**Application for a non-material amendment following a grant of planning permission,
Town and Country Planning Act 1990**

**Non material amendment to previous permission 2016/91501 for erection of first
floor side and rear extension, single storey rear extension and vehicular entrance
gates (within a Conservation Area)**

Braystone House, 32a, Wilshaw Road, Meltham, Holmfirth, HD9 4DZ

Application Number: 2016/93572

title elevations & specification as proposed  
number 16026D-06-P01  
scale 1:50  
size A1

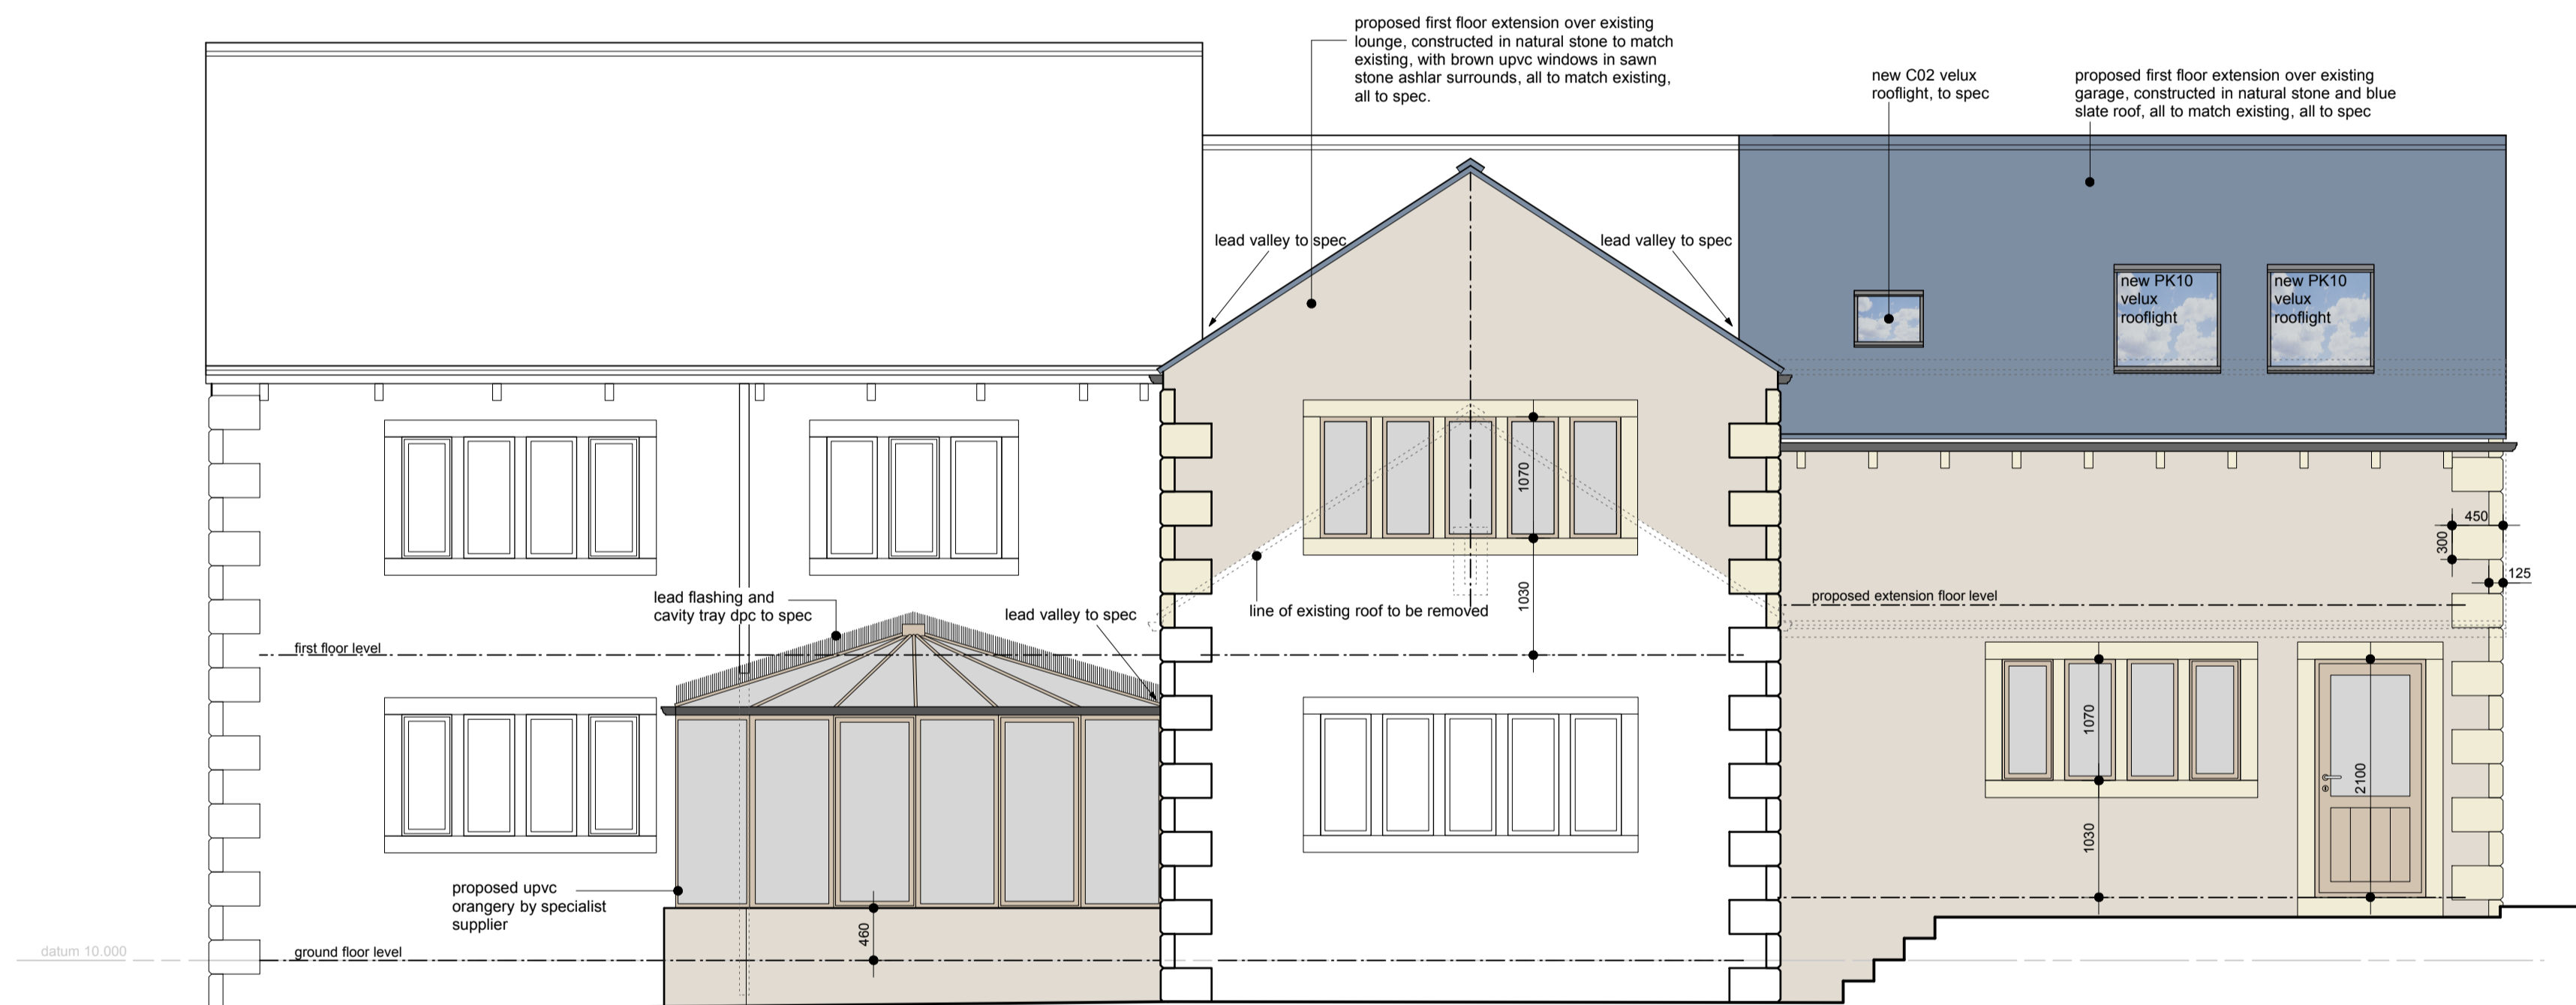
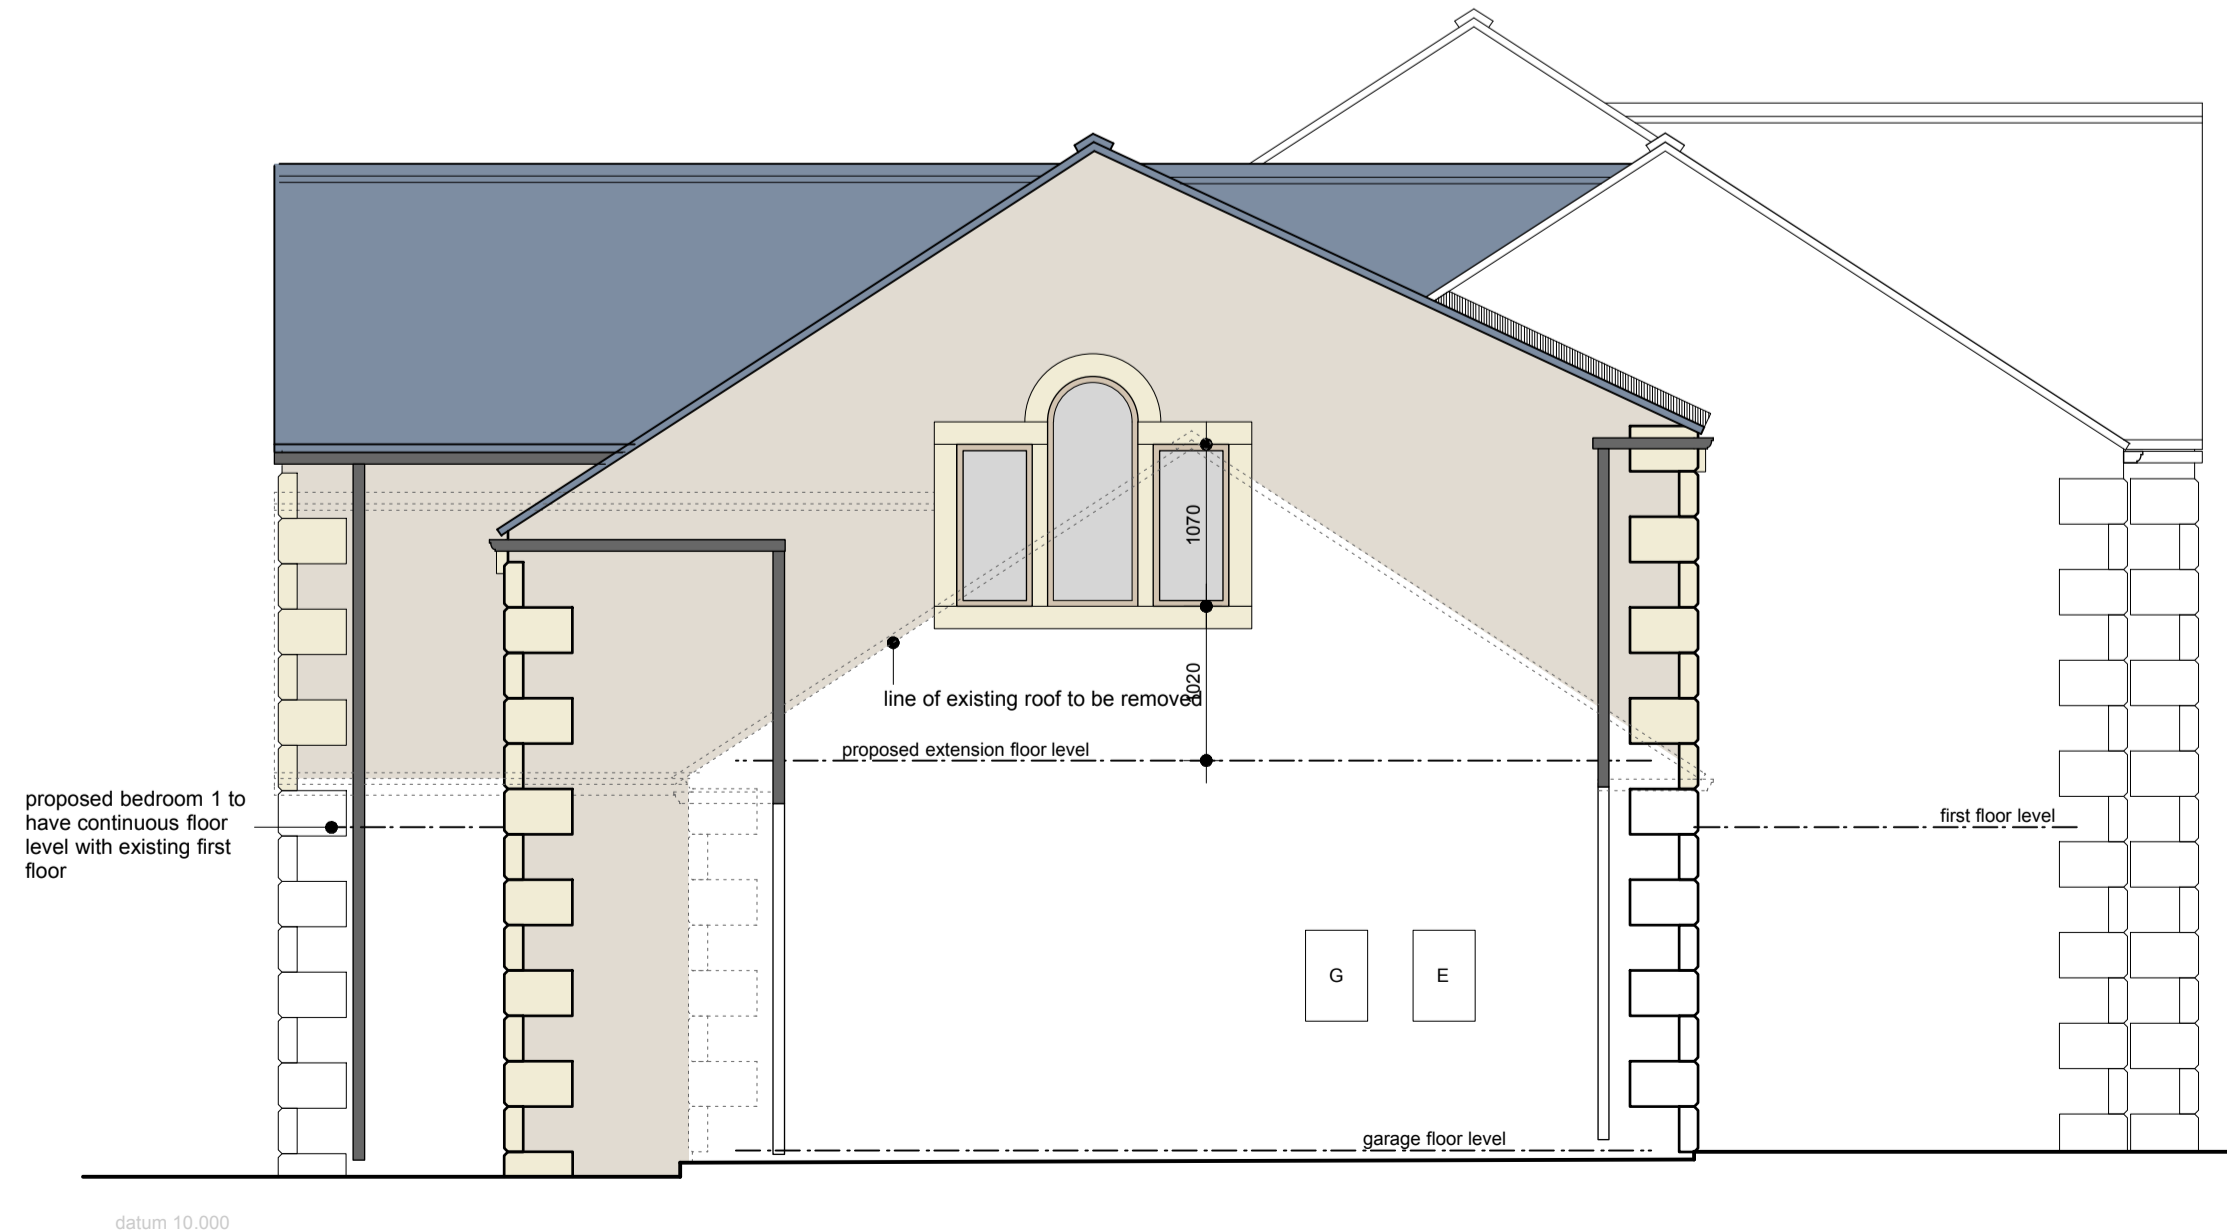
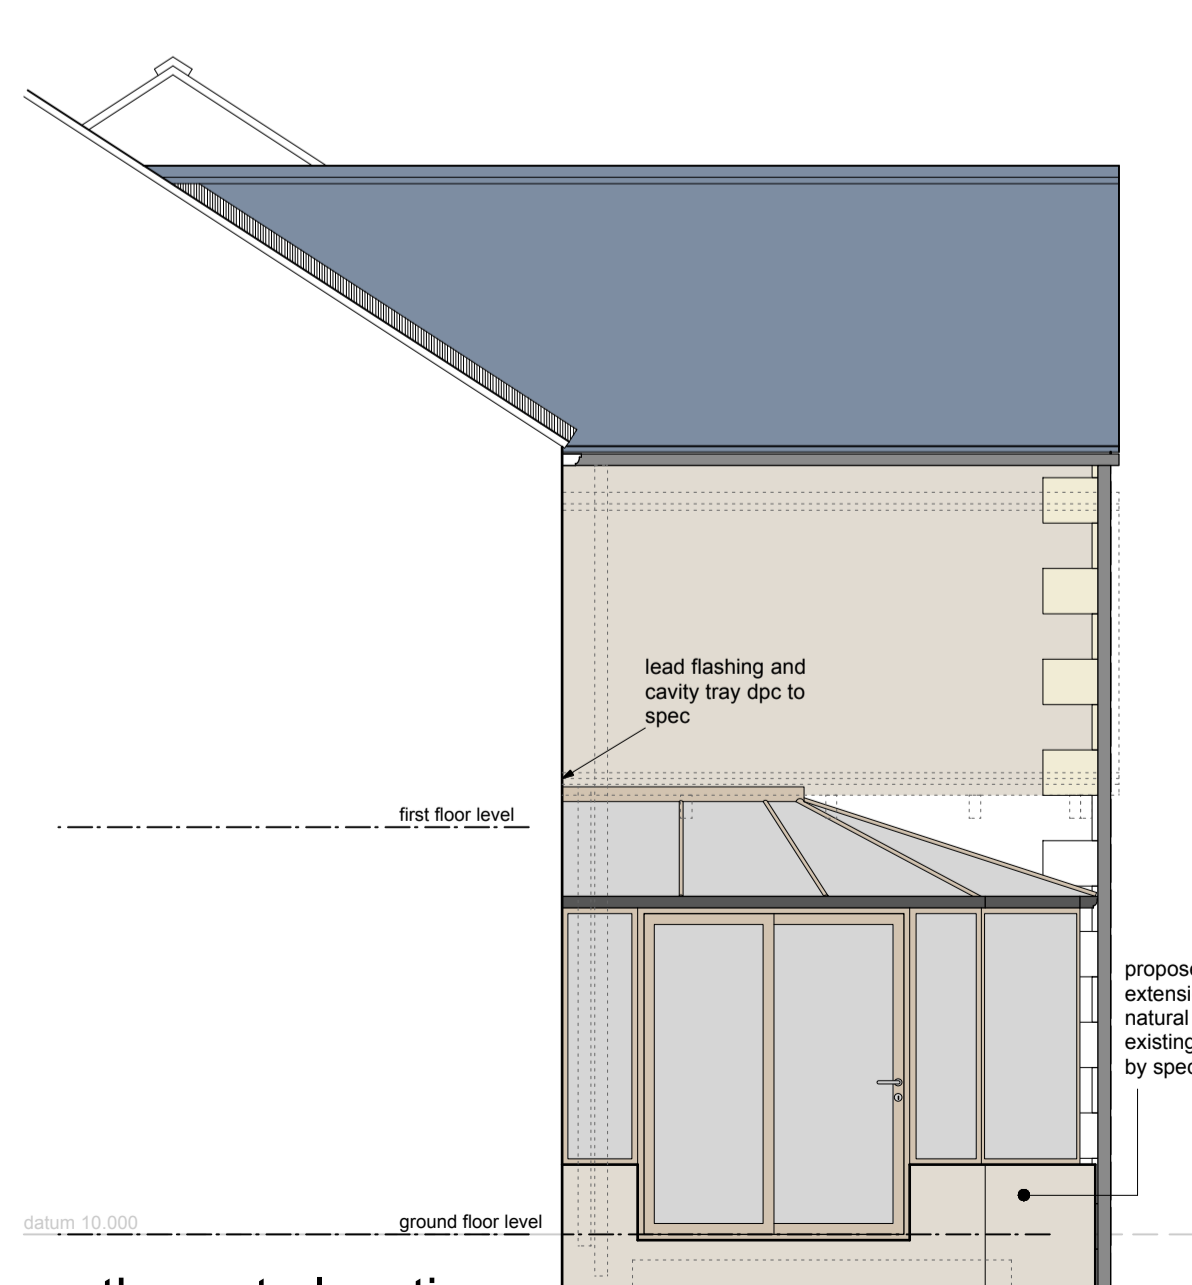
Thank you for your application dated 21-Oct-2016 for a non-material amendment to the above scheme. The amendment sought is to increase the height to ridge and eaves height of the side extension as indicated on drawing no.16026D-05-P01 titled "plans & sections as proposed" and drawing no. 16026D-06-P01 titled "elevations & specification as proposed" received by the Local Planning Authority on 25 October 2016.

I confirm that the alterations are acceptable and may be considered as a non-material amendment to the approved drawings. It should be noted that this letter relates only to the non-material amendment sought and it is not a re-issue of the original planning permission. The two documents should be read together and as such, all conditions imposed on the original granting of planning permission apply to the proposal as now amended. A copy of this letter and the amended plans will be retained on the public record of approved documents.
